Re: Sawmill Market
1909 Bellamah Ave NW, 87104
30-Day Temporary Certificate of Occupancy
Transportation Development Final Inspection
Engineer's/Architect's Stamp dated 10-1-18 (J13D017A)
Certification dated 2-11-20

Re: **Transportation Final Certificate of Occupancy**
Sawmill Market Phase 1
1909 Bellamah Avenue, NW, Albuquerque, NM

A1 SITE PLAN
1" = 20'-0"

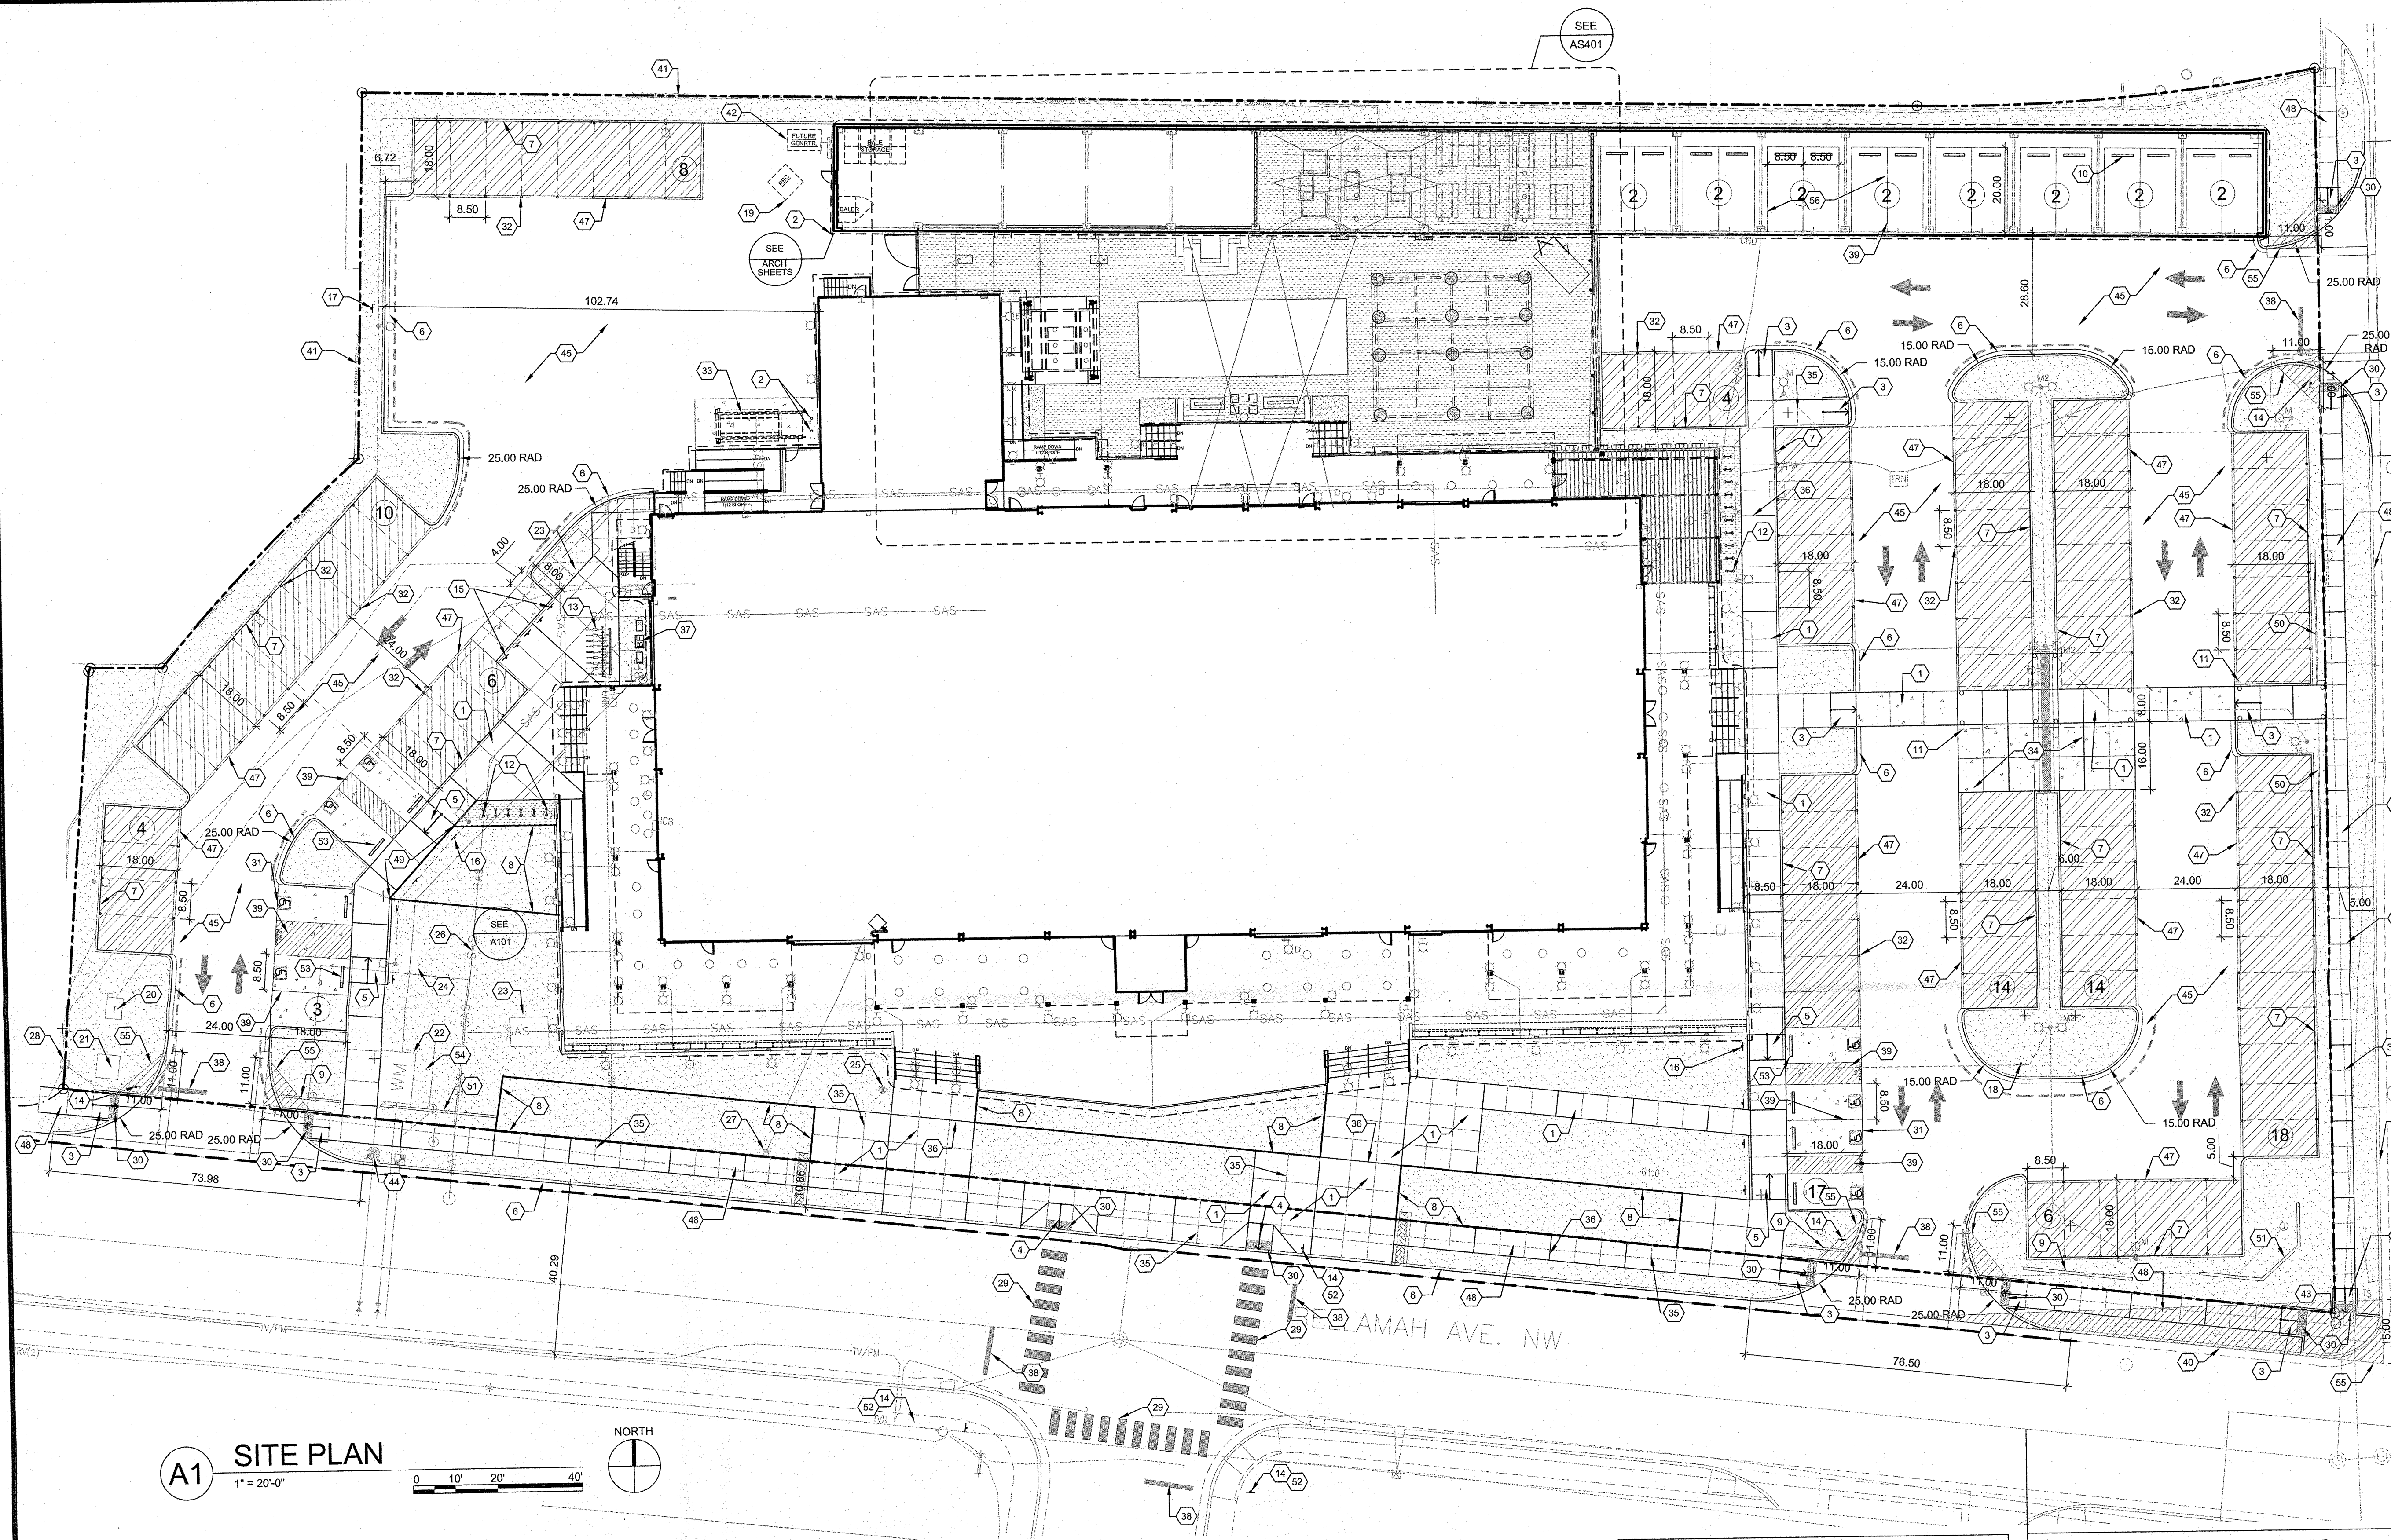
- Please add crusher fine paving under bike racks.
- Please remove construction equipment, debris, trash containers and porta potty.
- Please remove dirt and rock piles from parking stalls and access aisles.

1. Two parking spaces have been constructed as compact spaces due to site conditions.
2. The stabilized crusher fine paving has not yet been installed under the bike racks.
3. The parking lot screen walls have not yet been installed.
4. The backyard area (which is not part of the site circulation) is still under construction.
